**Subject:** EPC ENG Review  
**Page Index:** 1  
**Date:** 6/3/2021 10:59:26 PM  
**Author:** dsdrice  
**Color:**   
**Layer:**  
**Space:**  
**Page Label:** 1

April 6, 2021  
Traffic Impact Analysis  
Future traffic congestion at the Fontaine  
Boulevard/Walleye Drive intersection is  
identified here and in Figures 8c and 9c. The  
study identifies two potential alternatives to  
improve this condition. However, no  
firm recommendation for either alternative is  
made, either in the text or in Table 3. Include  
a firm recommendation for mitigation.

**DEVIATION  
EXHIBIT**

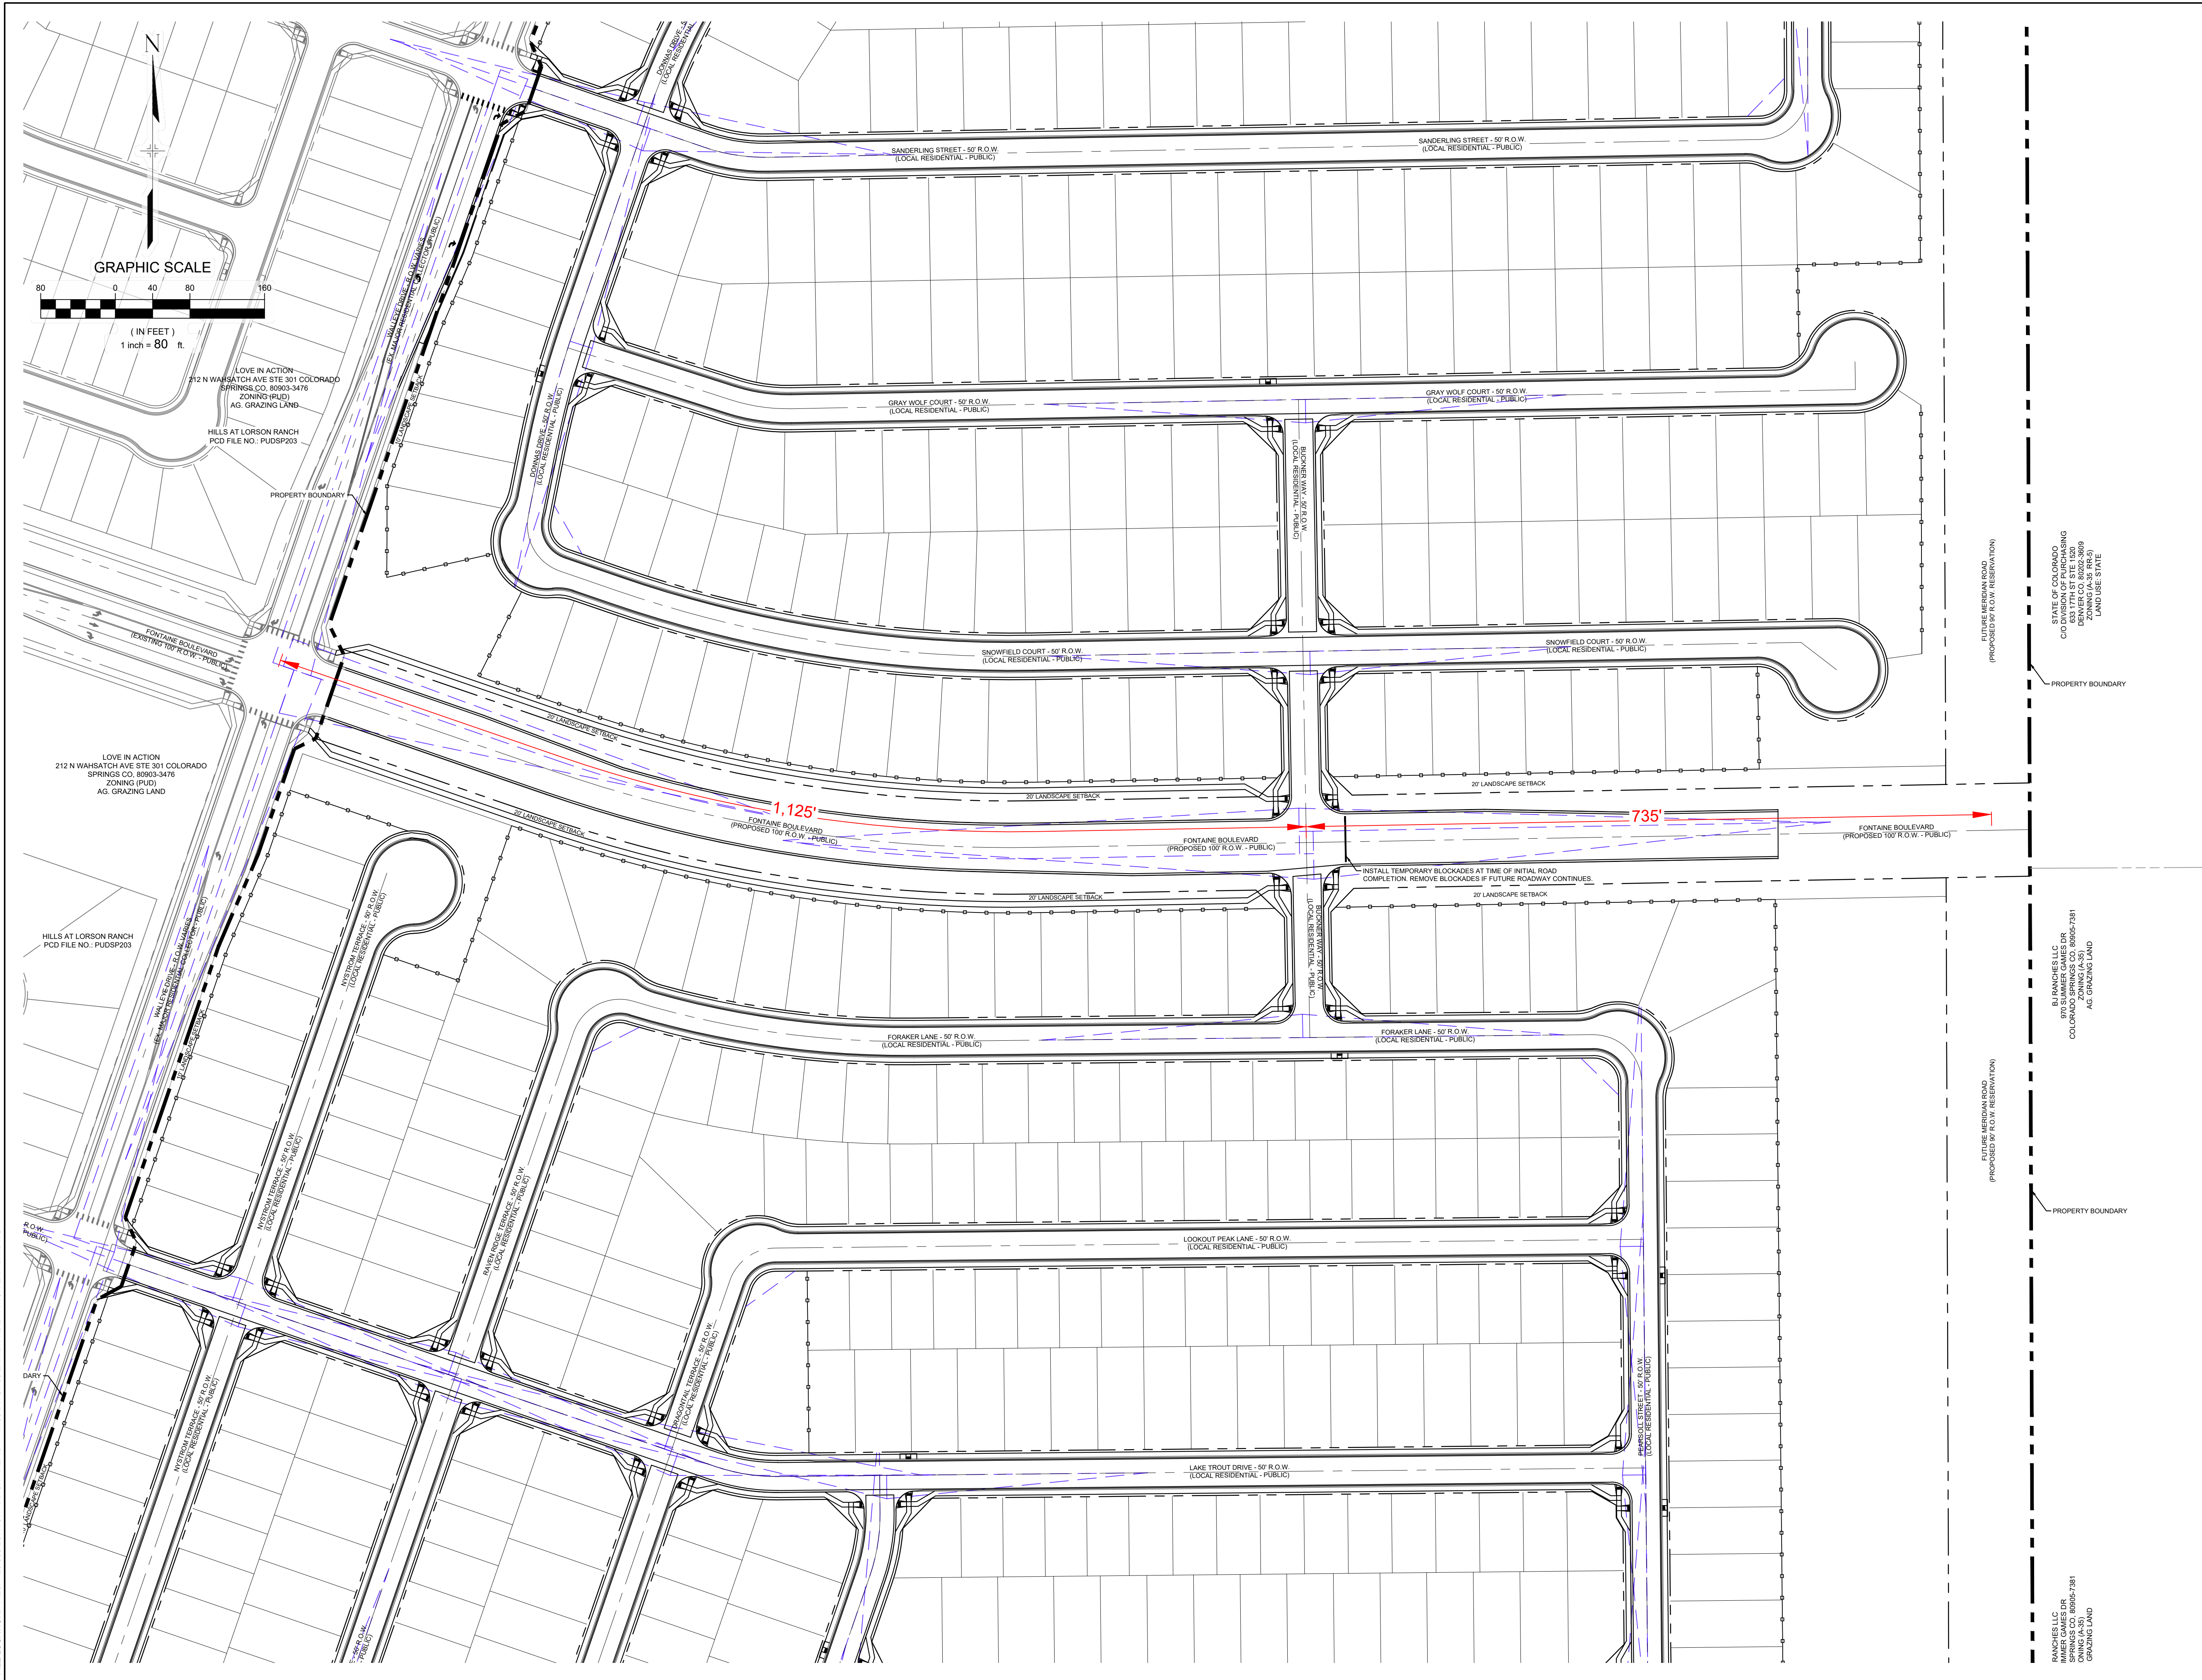
address this future intersection spacing
